Development Facilitation Team (DFT) – Review Comments

Project No: PR-2024-011129 **Date:** 6/11/2025 **Agenda Item:** #12 **Zone Atlas Page:** B-20

Location: 9001 Modesto Ave NE

Application For: – VA-2024-00313 – SIKEWALK WAIVER

SHEET NUMBER:
A1.1

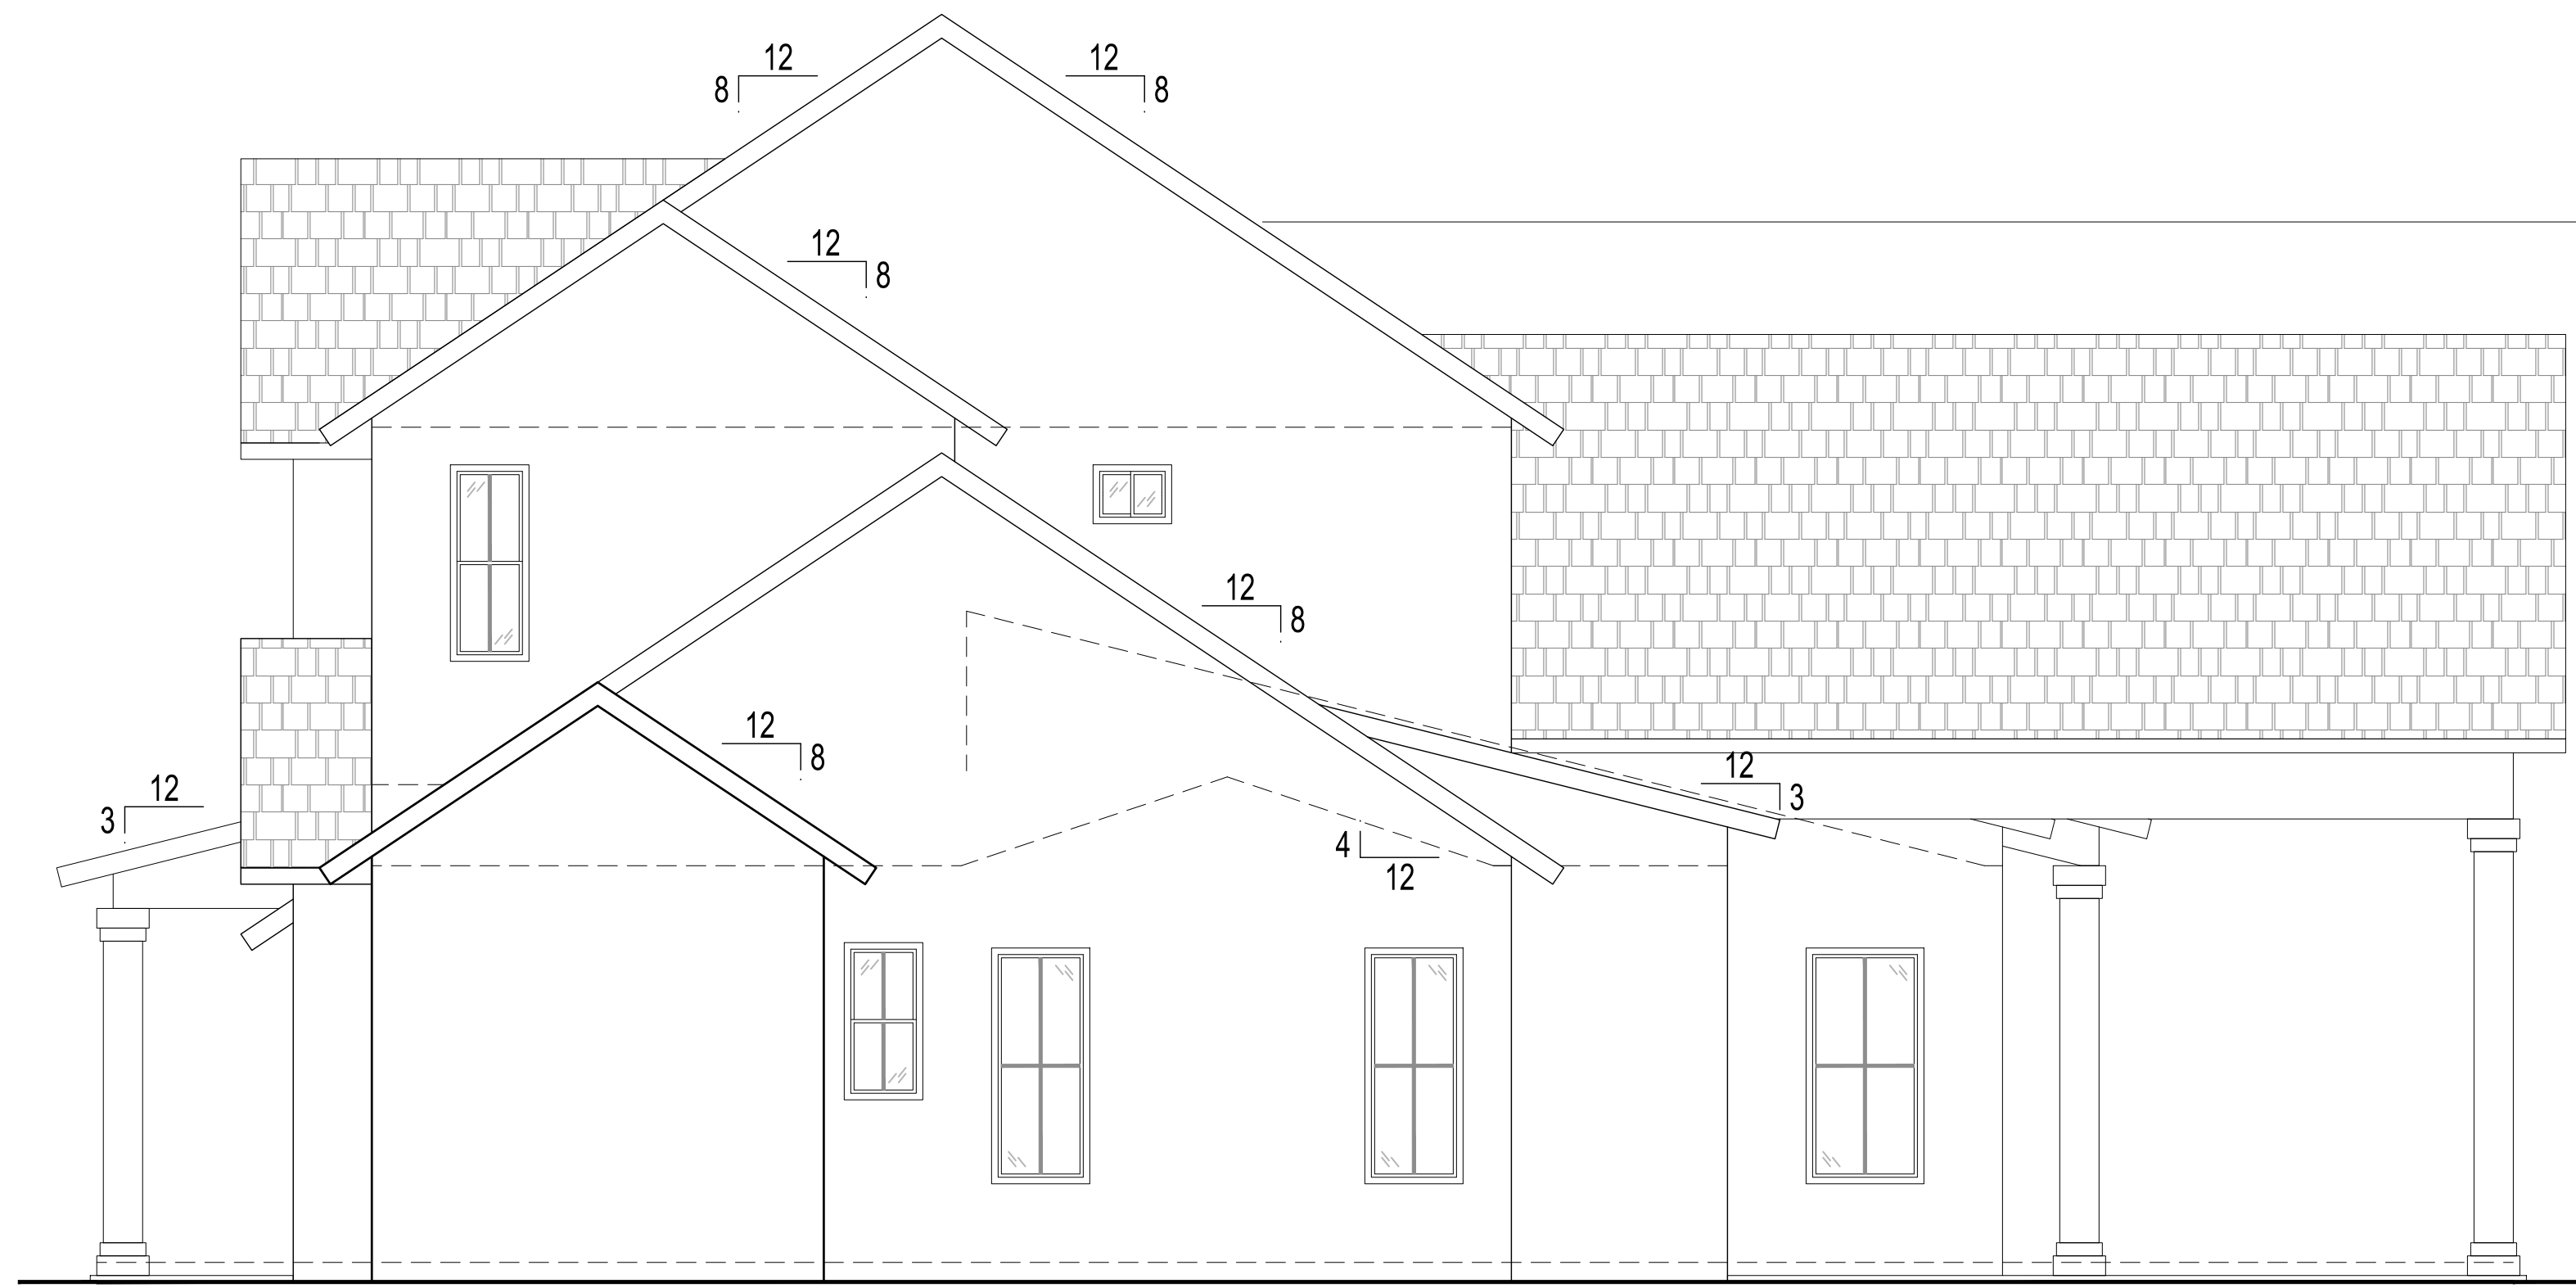
1. Modesto is a minor collector and requires curb, gutter, 6' sidewalk with a 5' to 6' landscape buffer. Transportation is not in support of the waiver of sidewalk in this area.

- Per 6-6(P)(2)(e) of the IDO, any Waivers granted that are associated with a Site Plan (the proposed single-family residential dwelling would require a Site Plan Administrative approval with a Building Permit(s)) shall be noted on the approved Site Plan.
- Transportation in their memo notes that ROW dedication could potentially be required. If ROW dedication is required, this would require a platting application to be submitted for DHO approval.

ENGINEER'S SEAL	9001 MODESTO AVENUE N.E. ALBUQUERQUE, NM	DRAWN BY BL
	PRELIMINARY DRAINAGE PLAN	DATE 05-09-2025
		2024002_GR&DR
	TIERRA WEST, LLC 5571 MIDWAY PARK PLACE NE ALBUQUERQUE, NM 87109 (505) 858-3100 www.tierrawestllc.com	SHEET # 2 JOB # 2024002

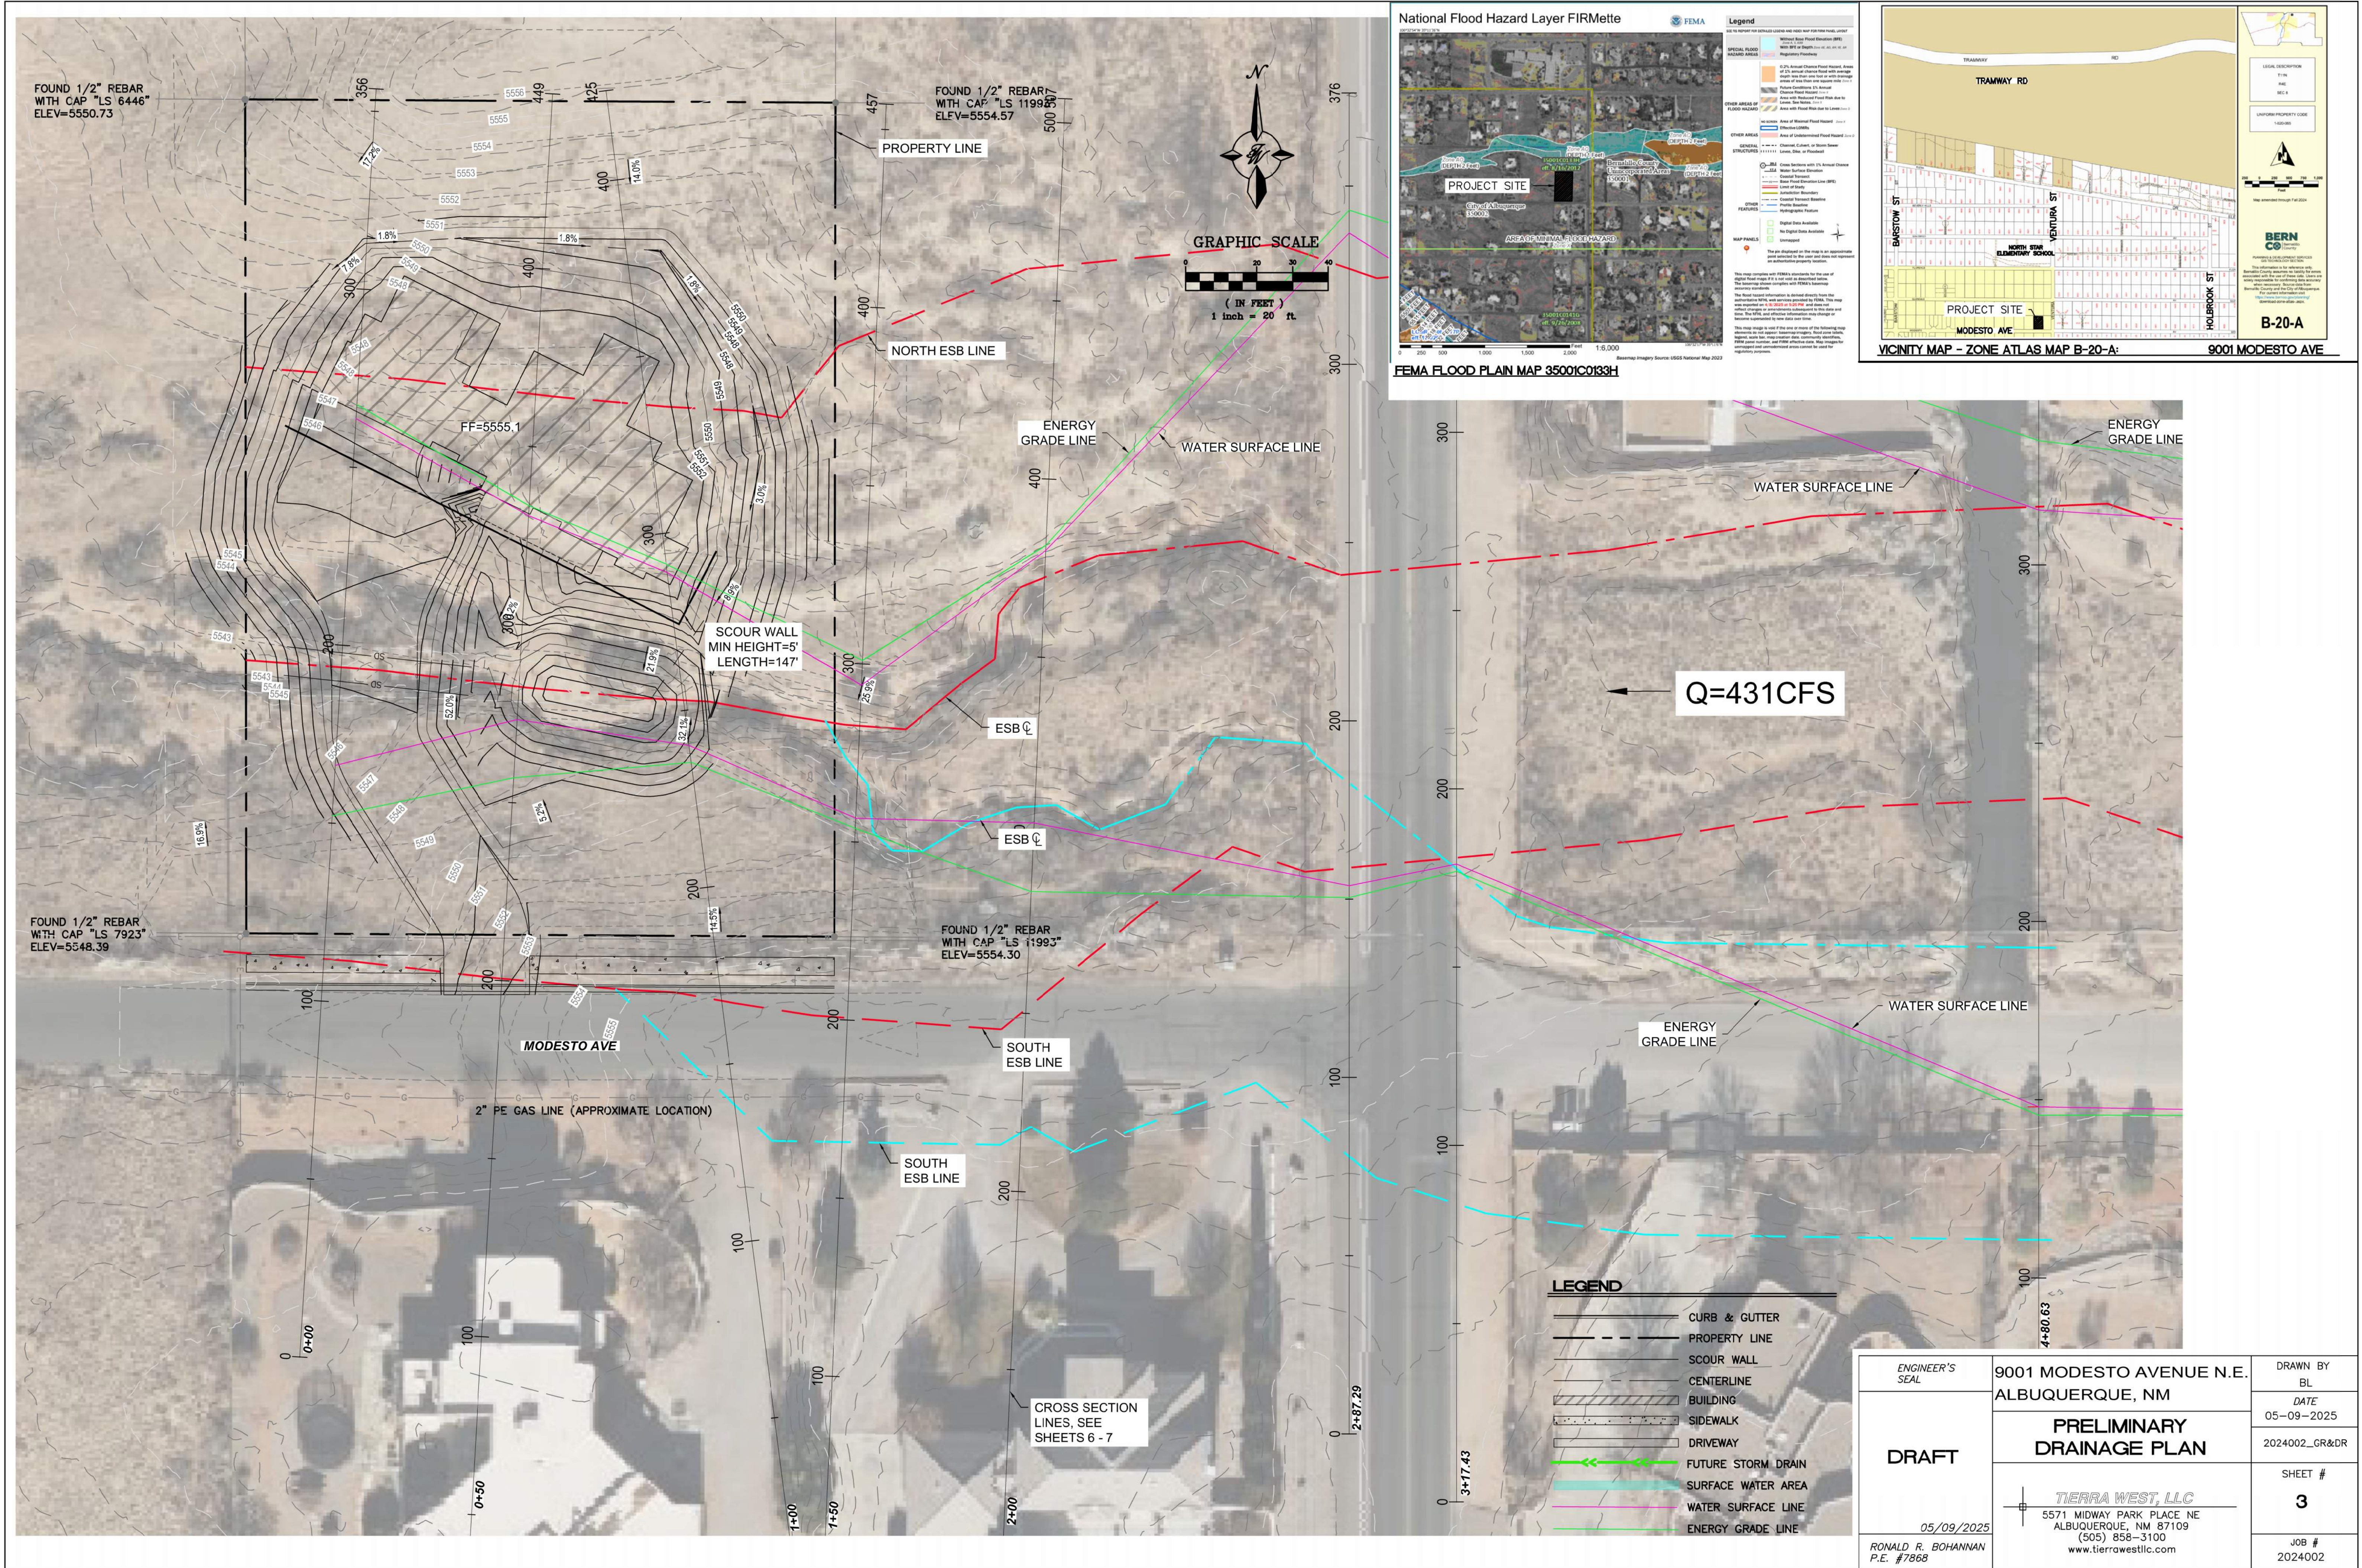
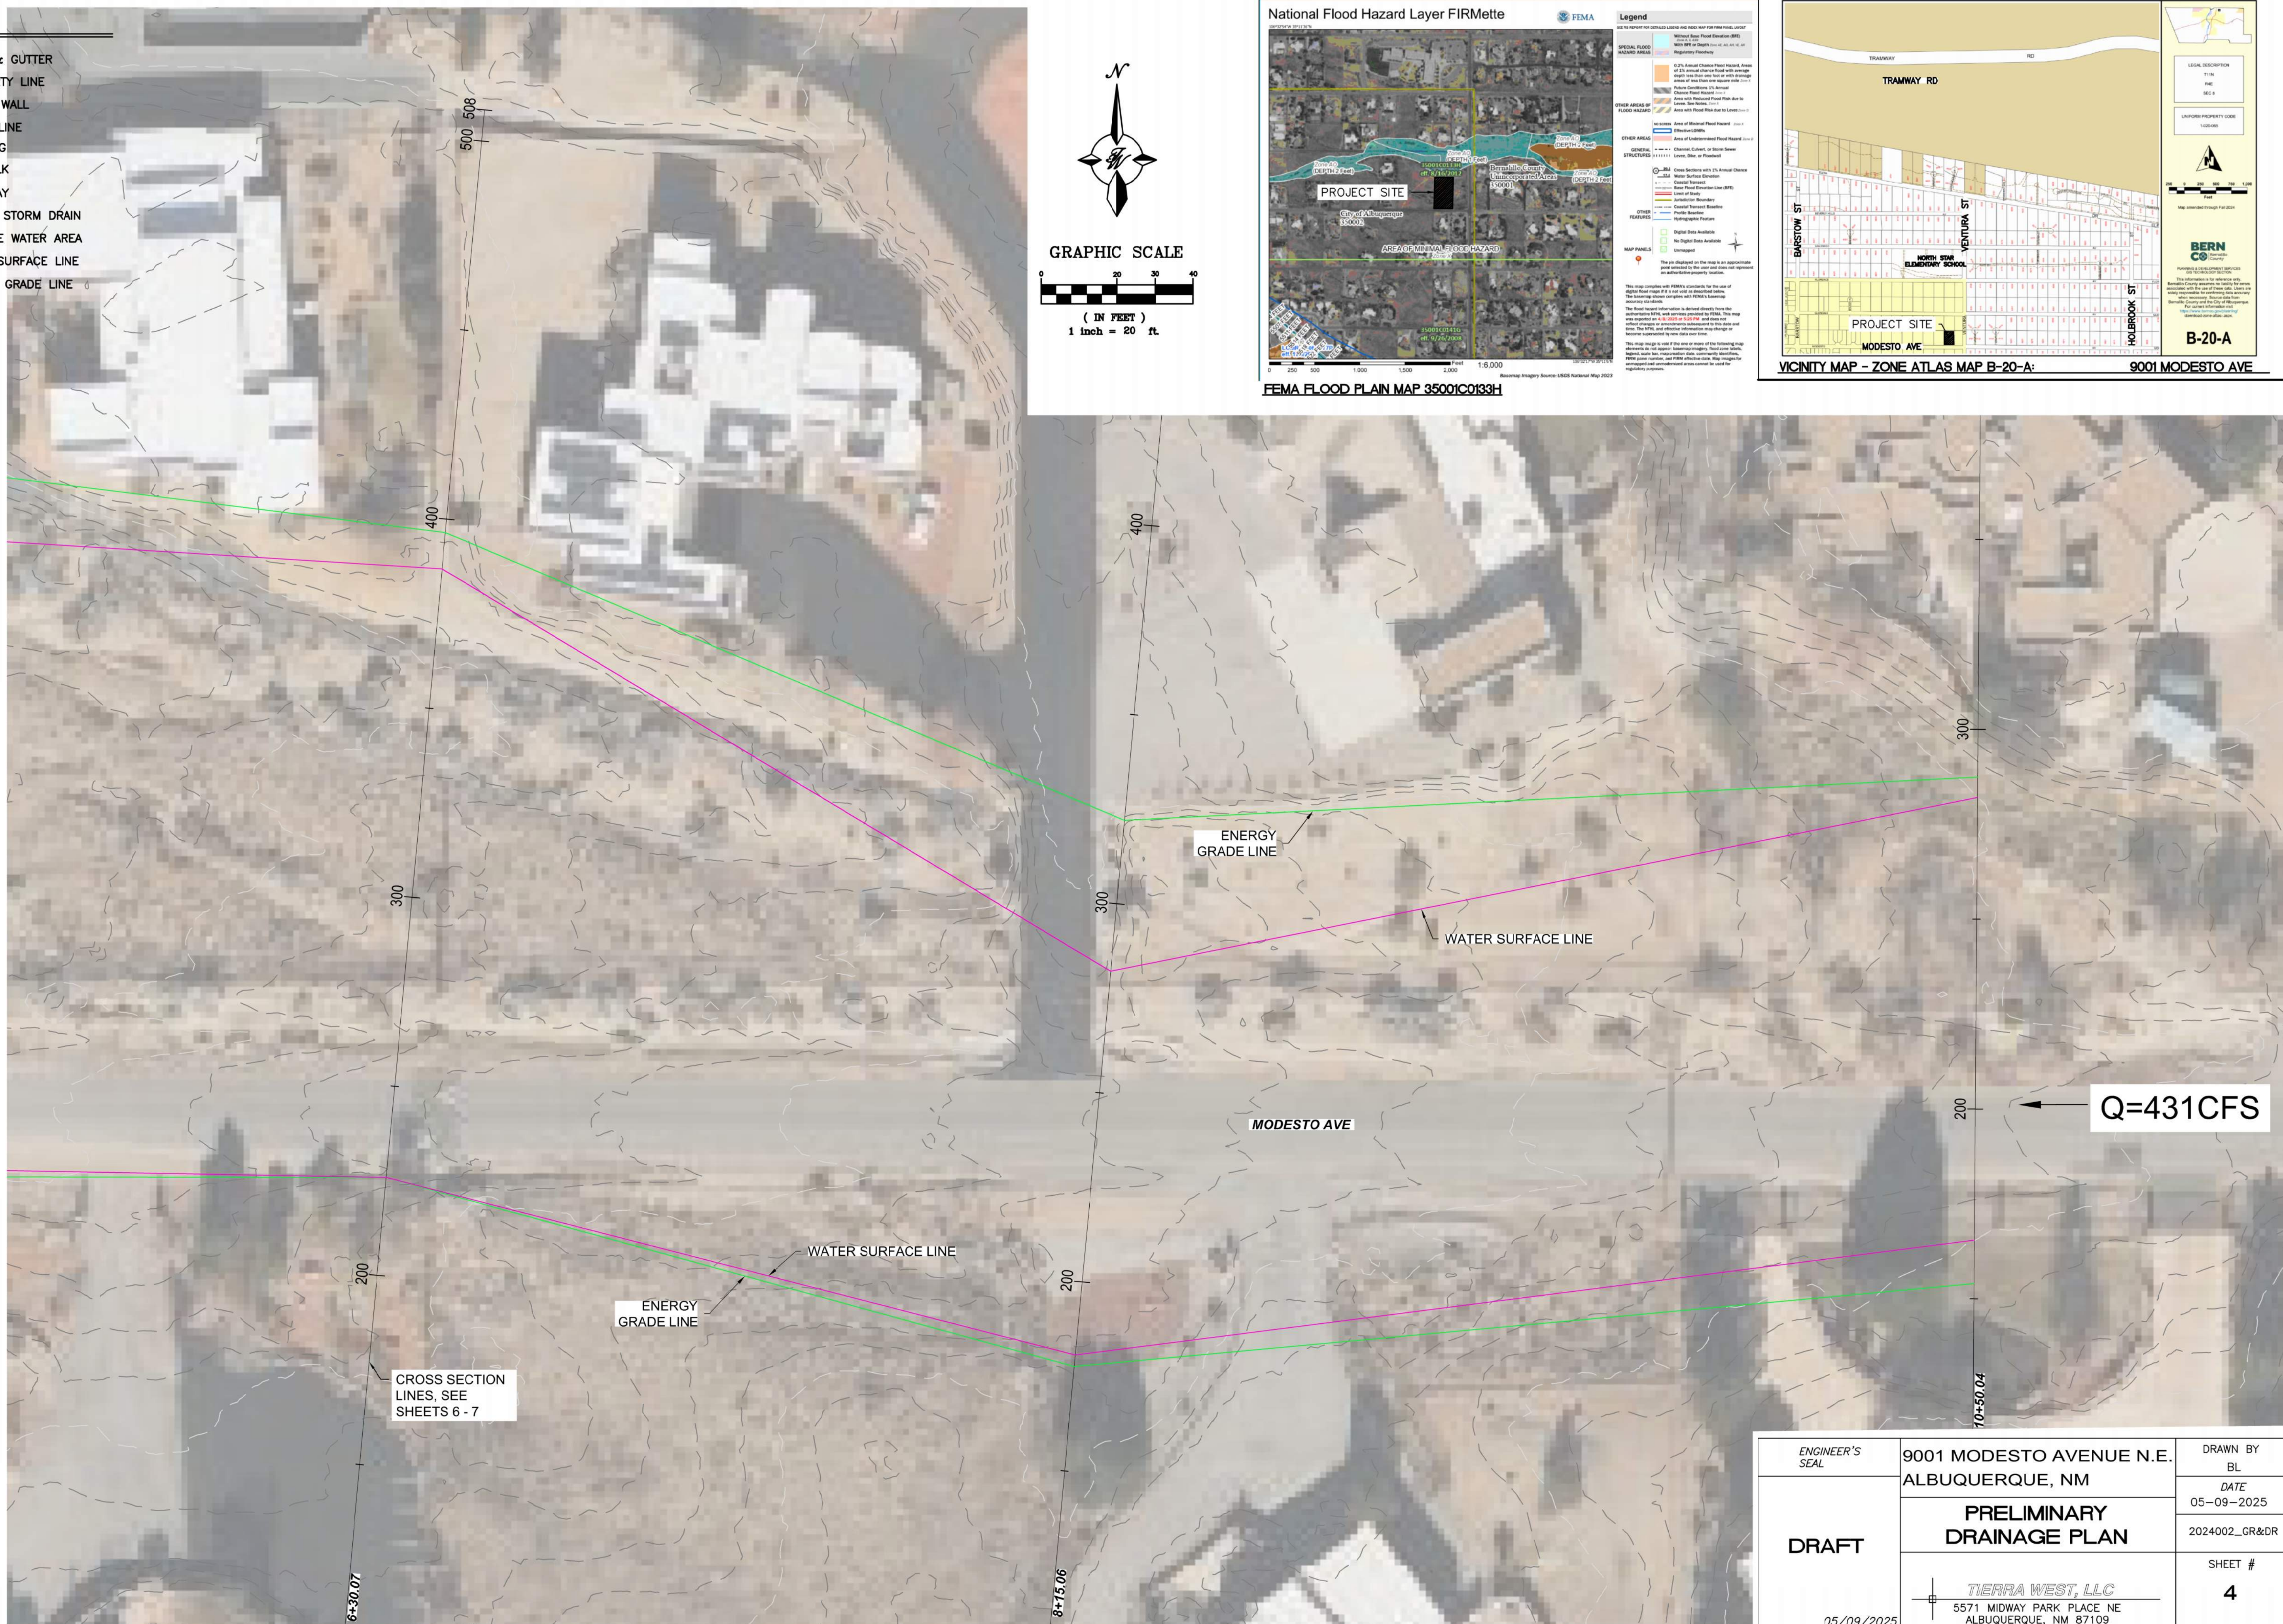
- Hydrology objects to the Sidewalk Waiver action due to essential roadway curb, gutter, and sidewalk improvements needed to mitigate or prevent adverse effects from stormwater drainage or runoff onsite and/or in the public R/W.
- Prior to submitting for a Grading Permit or a Building Permit for any site upgrades, a licensed New Mexico civil engineer will need to submit a Grading & Drainage Plan to Hydrology for review & approval if one of these conditions is met: (500 cy of grading, 1,000 sf of proposed building, or 10,000 sf of proposed paving).

6-6(P)(3)(1)(a)(1)c. The arroyo mentioned flows ~70' north of the roadway through the property and would not be impacted by the addition of the sidewalk, curb and gutter. The drainage master plan calls for storm drain to be installed in the intersection of Ventura and Modesto and routed north to Glendale which will cut off most of the flows west of the intersection. The new supplemental submittal with building permits listed without financial guarantees for curb, gutter and sidewalk do not represent what the applicant hoped. 2 of the 7 were permits for interior alterations and generated no site plans for review, 3 were additions smaller than 1000 sf so no new G&D's required (so no review of sites by DRS), 1 shows an incorrect address (8600 Modesto when permit is for 8527 Modesto) has sidewalk and 1 was the Florence address has a waiver approved by the applicant which was strongly opposed by Transportation. The only reason an appeal was not made on this case was that there was an ordinance change working through City Council at the time that would assess fronting properties for infrastructure improvements which would have made the waiver moot. The ordinance did not pass council.

6-6(P)(3)(1)(a)(2). The claim that City would be required to install storm drain if the waiver is not allowed is not supported by evidence and is contrary to City Hydrology.
